July 3, 2023

Re: **Marysville 44th PRD – PA22-024 – Concurrency Recommendation**

Jesse Hannahs, PE
Traffic Engineering Manager

DRAWING: **C3**
 SHEET: **3** OF **9**

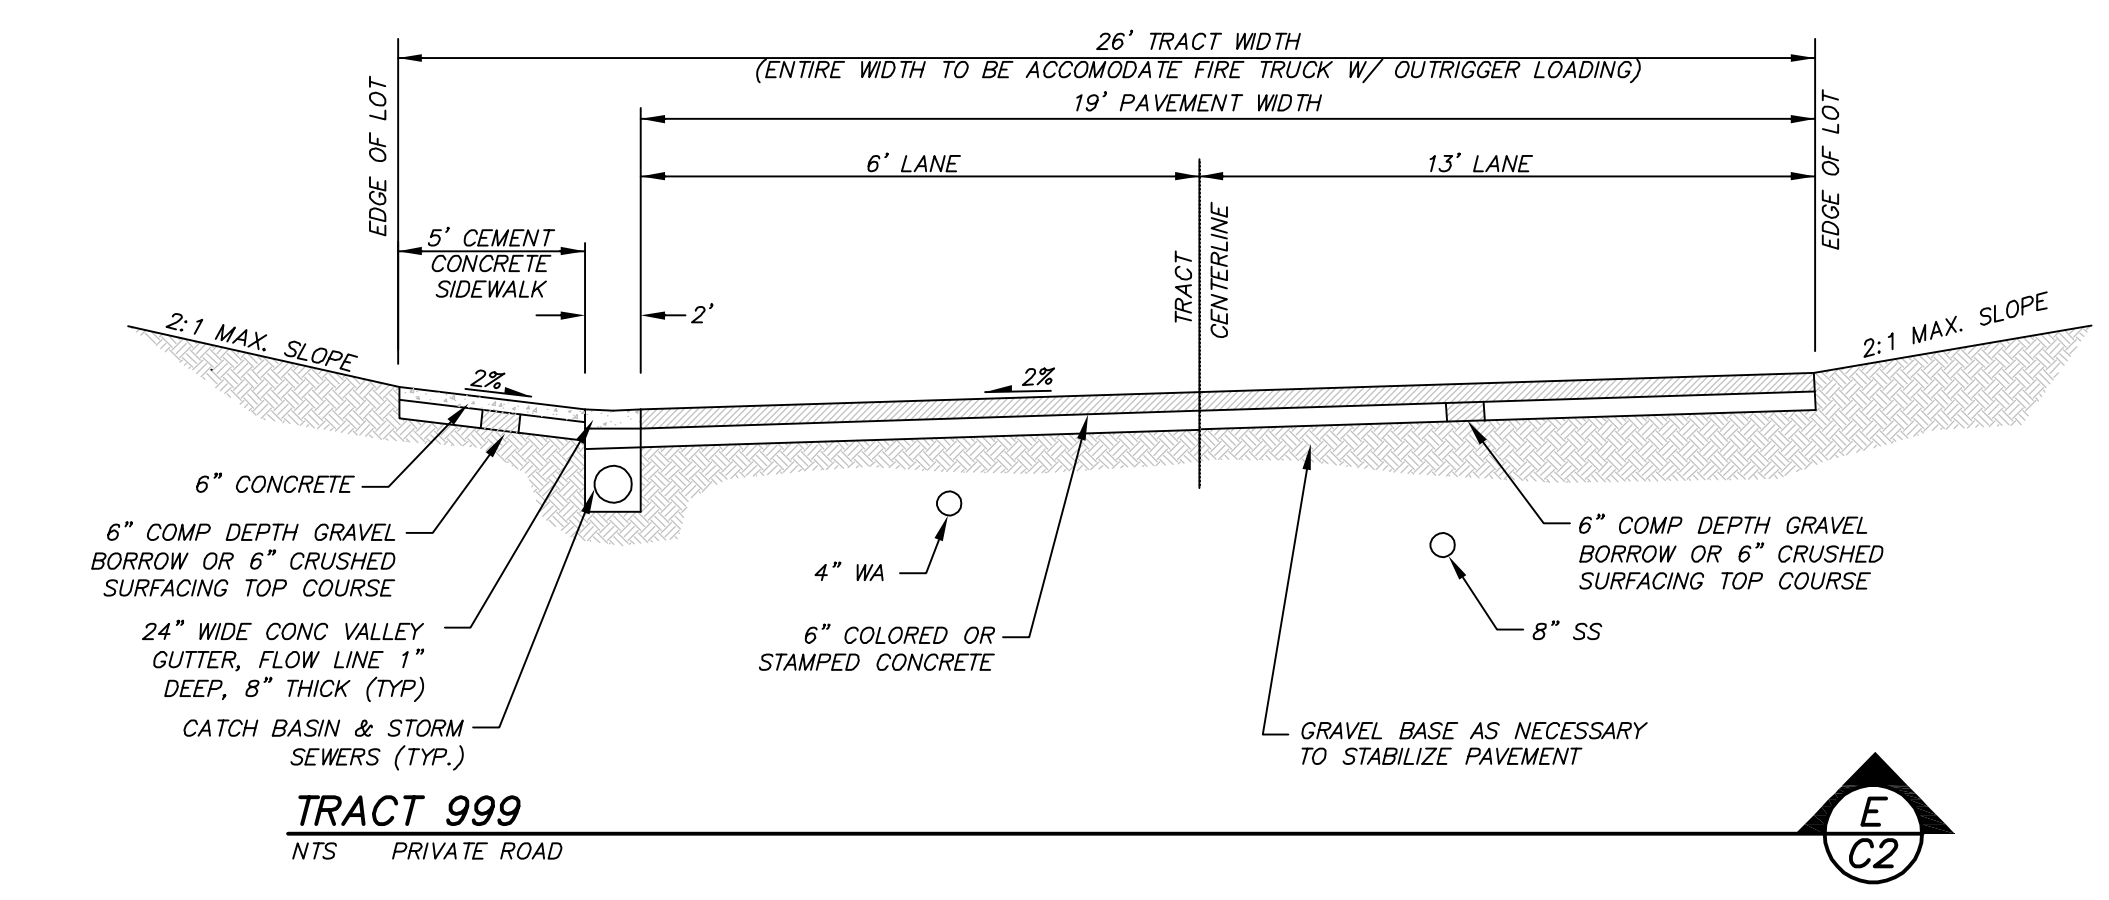
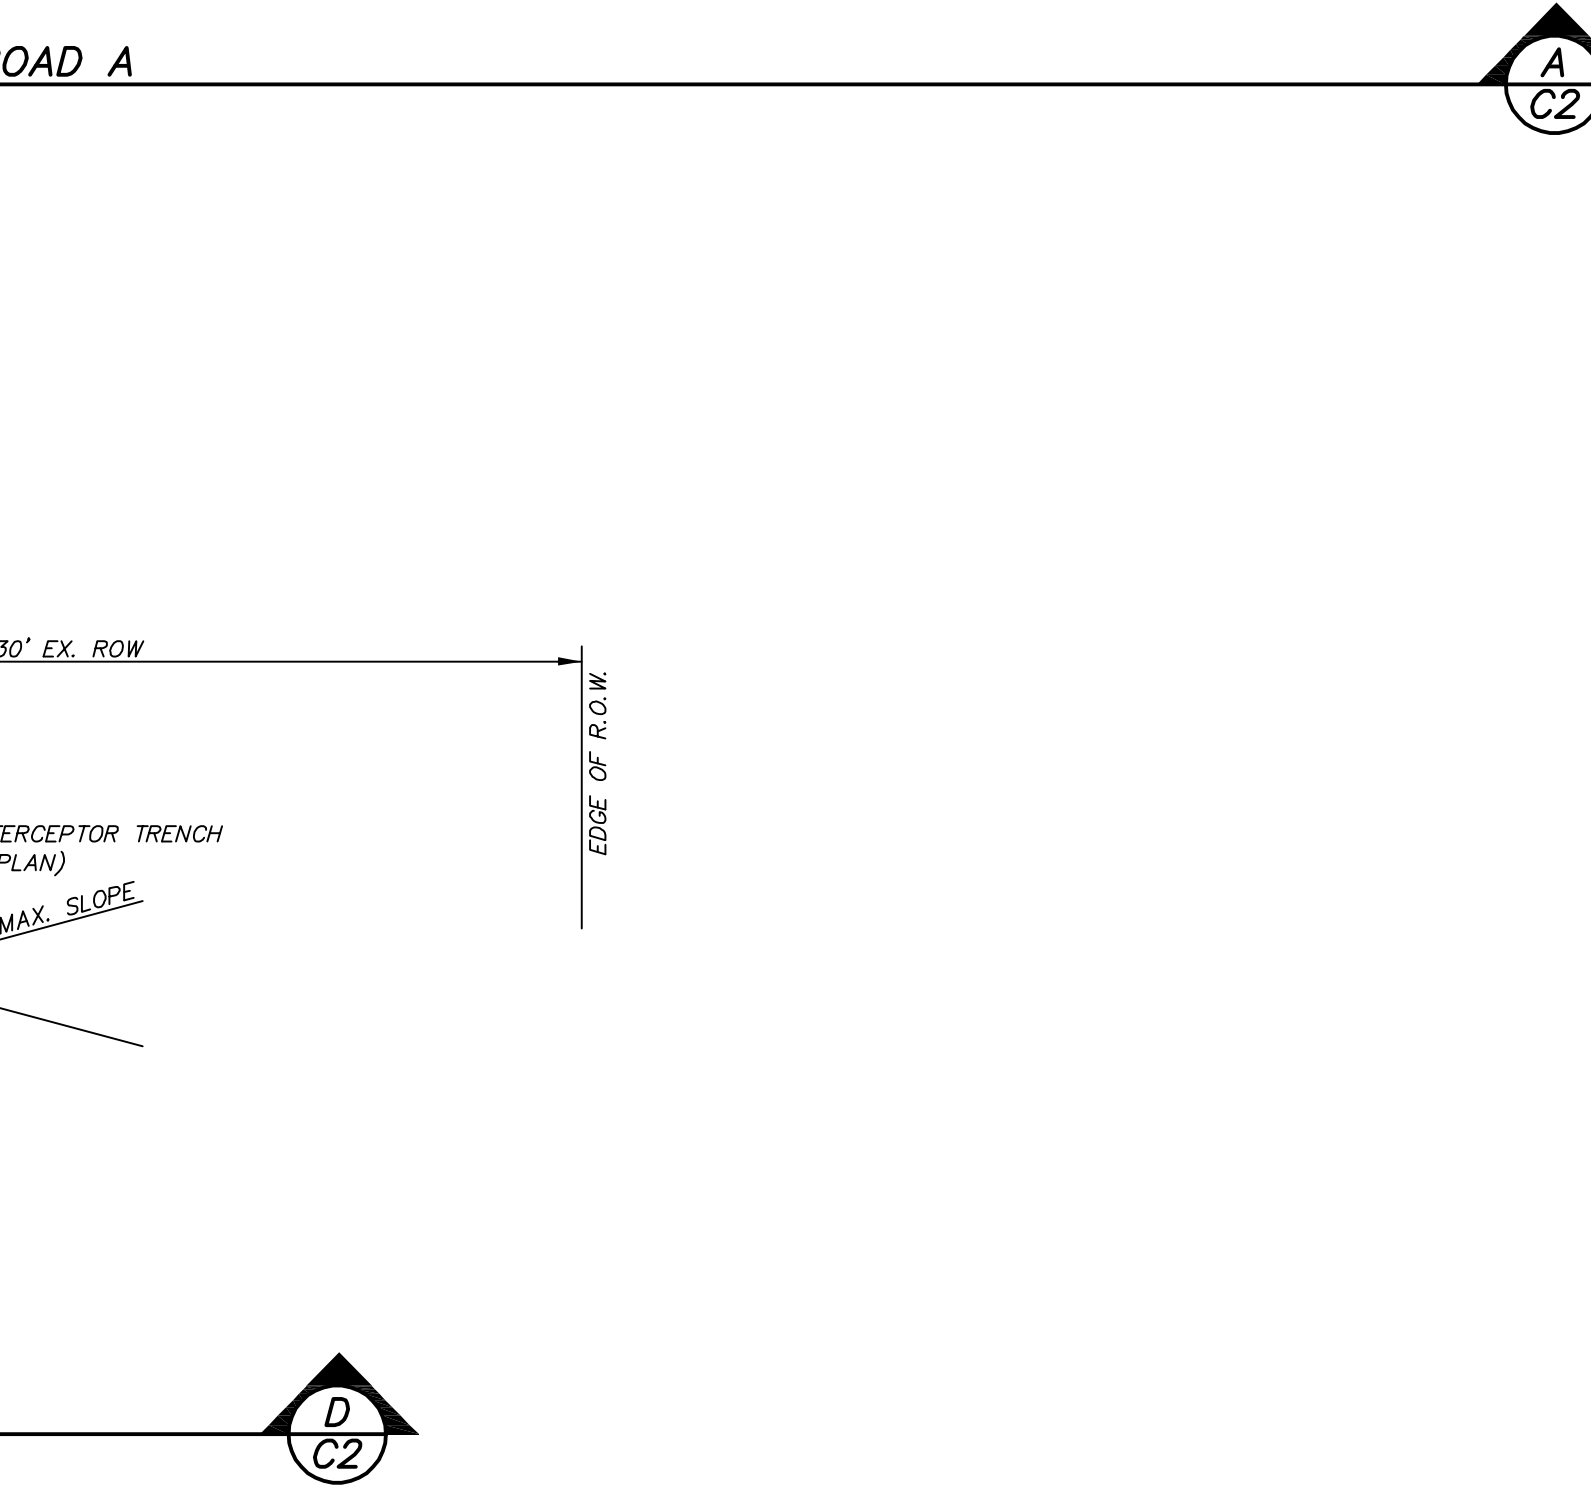
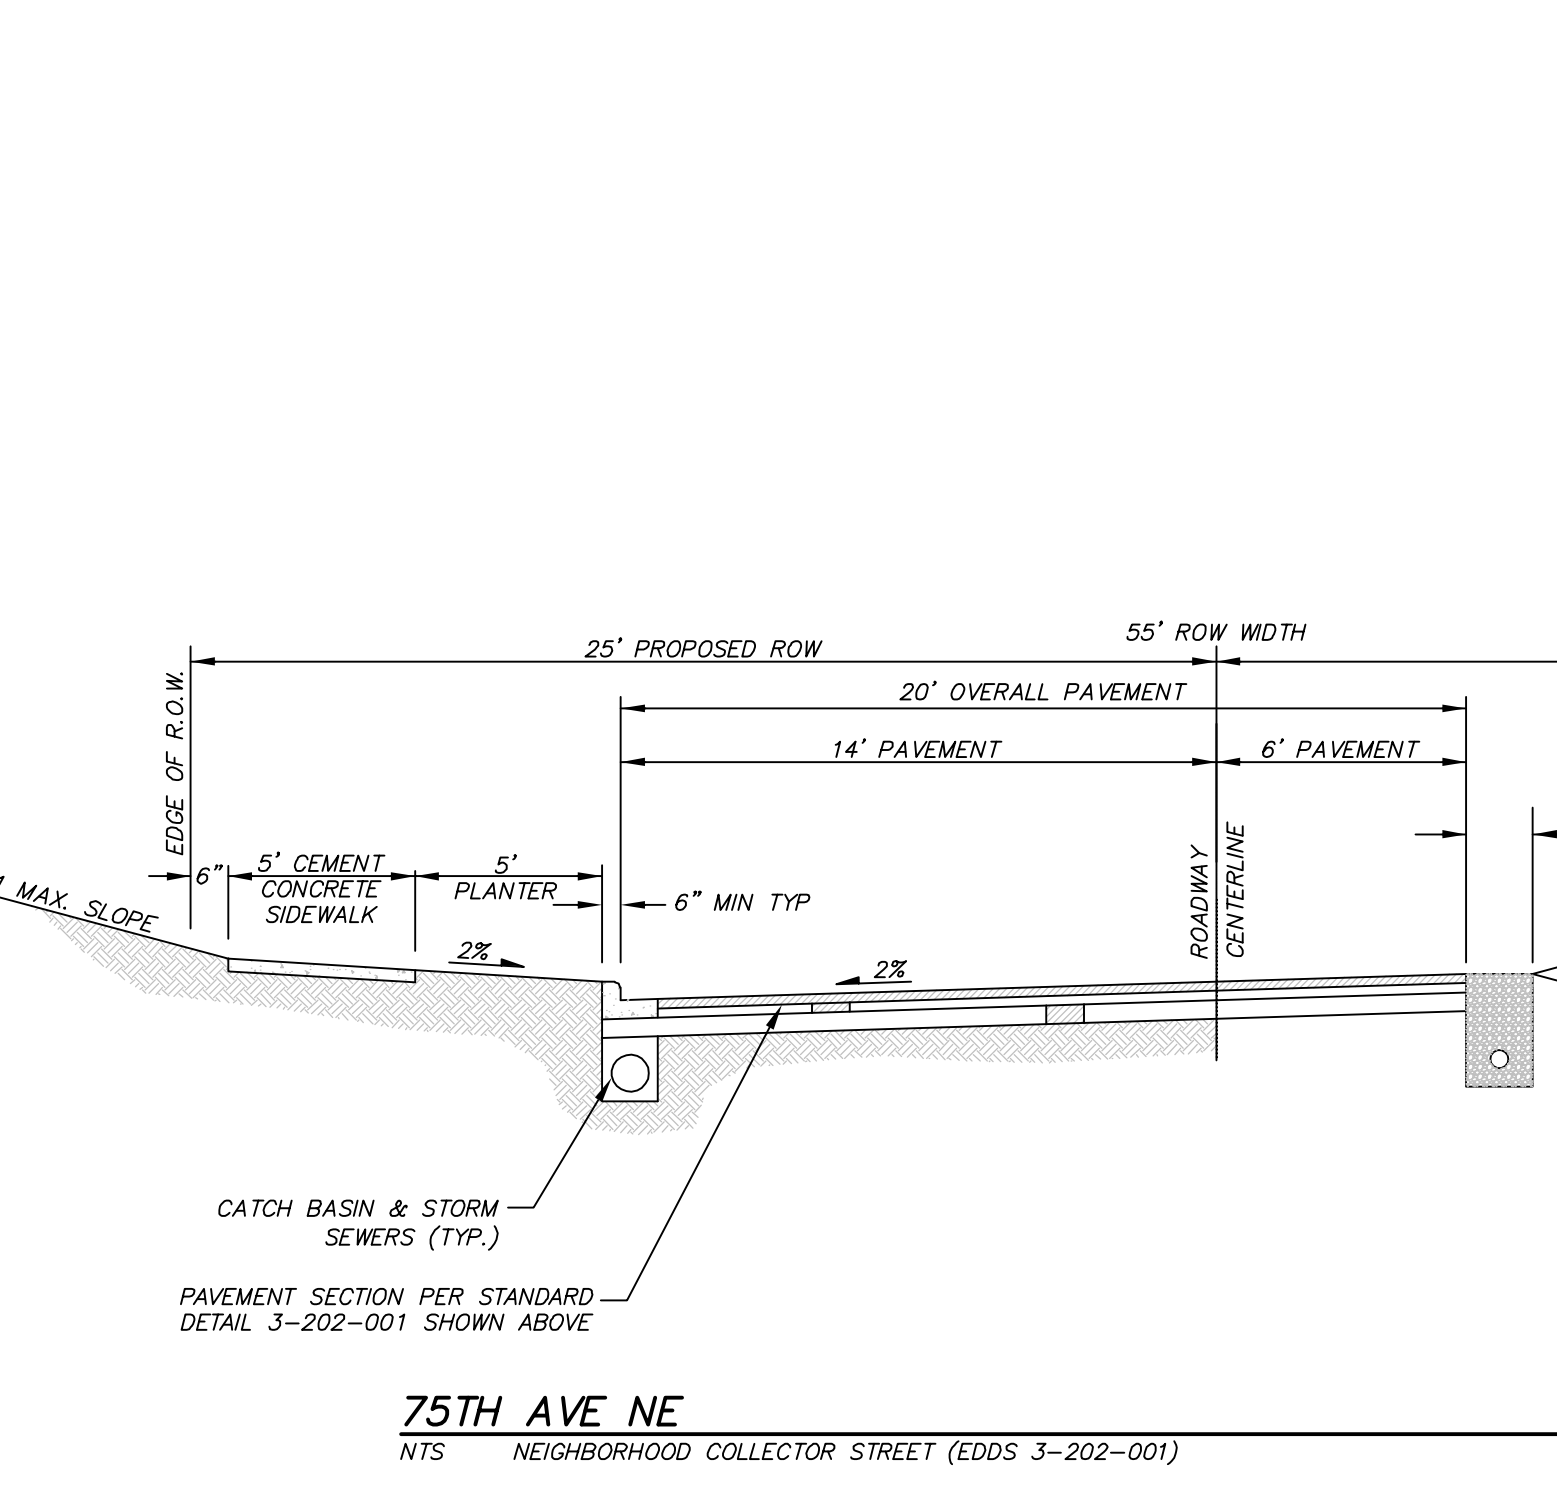
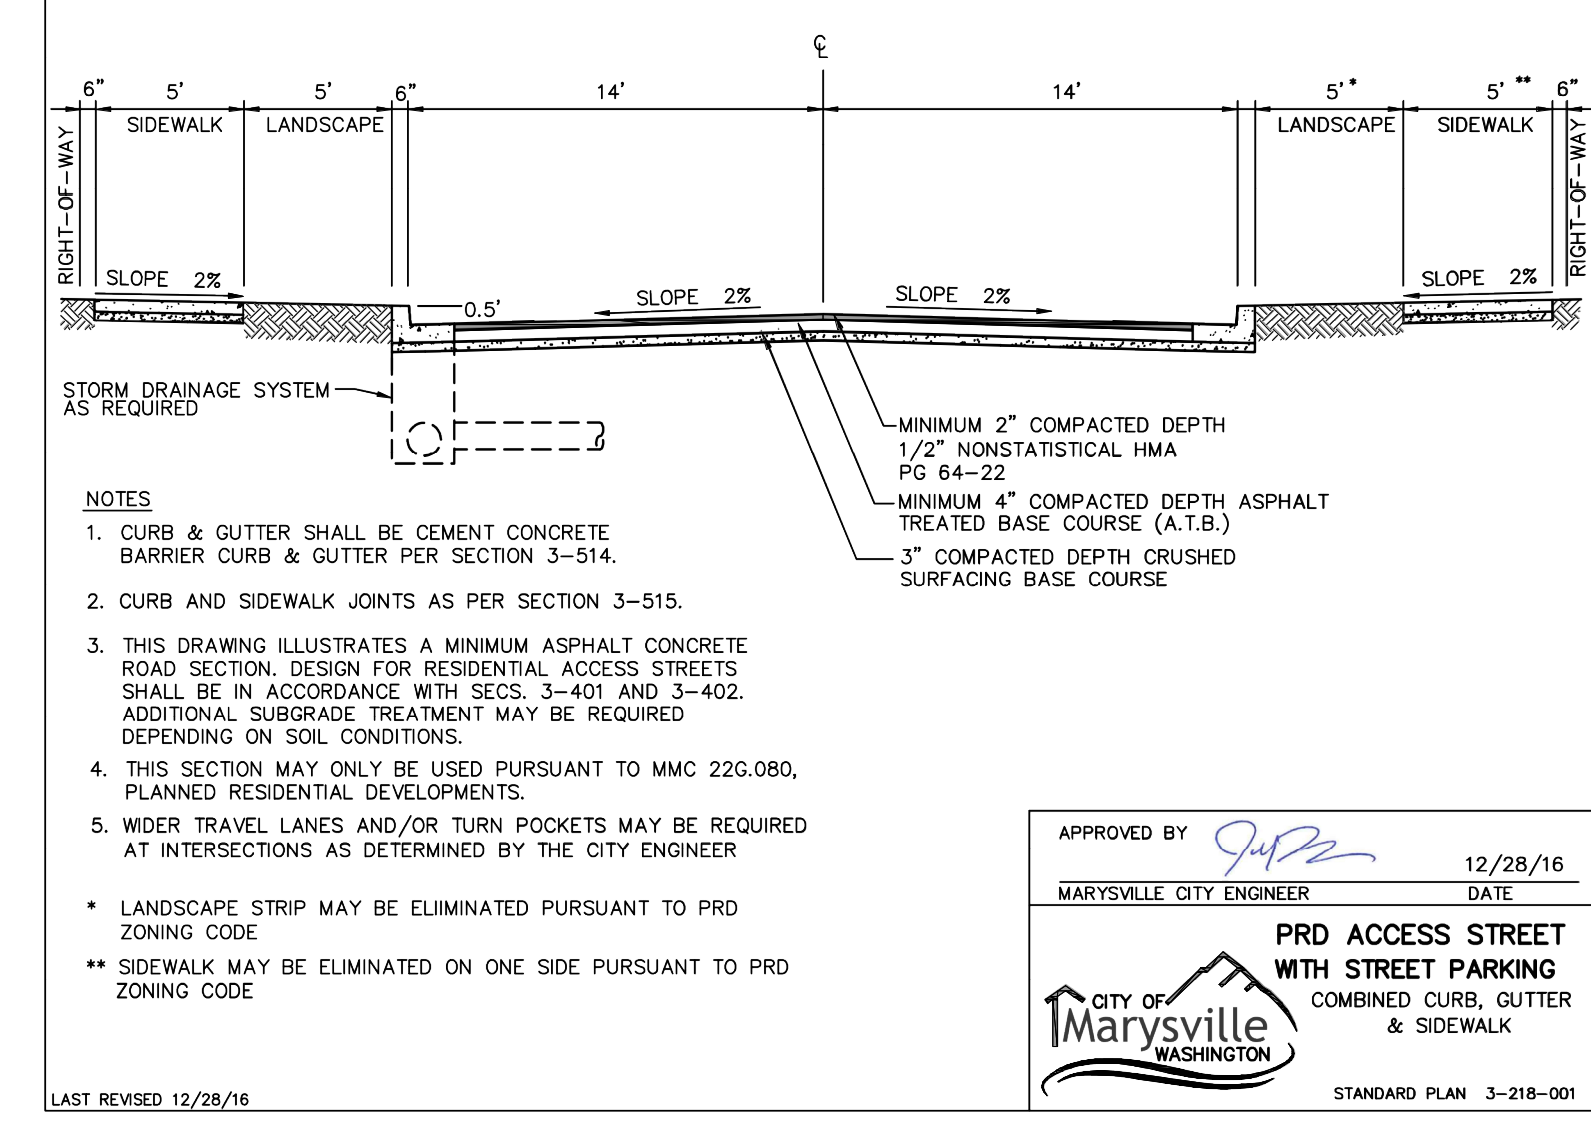
1. The applicant shall be required to construct frontage improvements along 44th Street NE and 75th Avenue NE, prior to final plat approval. Roadway improvements, channelization, site access and lighting plans shall be required to be reviewed and approved by the City Engineer, prior to construction plan approval.
 - 1.1. The westbound right-turn deceleration lane on 44th Street NE shall be consistent with WSDOT’s Design Manual (DM) Exhibit 1310-21 to mitigate sight-distance. The multiplier for downgrade shall also be evaluated.
 - 1.2. The westbound acceleration lane on 44th Street NE west of 75th Avenue NE shall be consistent with WSDOT’s DM Exhibit 1310-22. The northern 44th Street NE curb line shall be shifted south as feasible to create a planter strip up to the width shown in EDDS Plan 3-201-007

The design speed for the southbound right-turn curve may be used to interpolate this lane length. The multiplier for downgrade shall also be evaluated. The taper rate in EDDS 3-406 should be used instead of 300 ft.
2. The applicant shall be required to dedicate public right-of-way in order to accommodate the required frontage improvements along 75th Avenue NE and 44th Street NE and the new internal roadway (Road A),
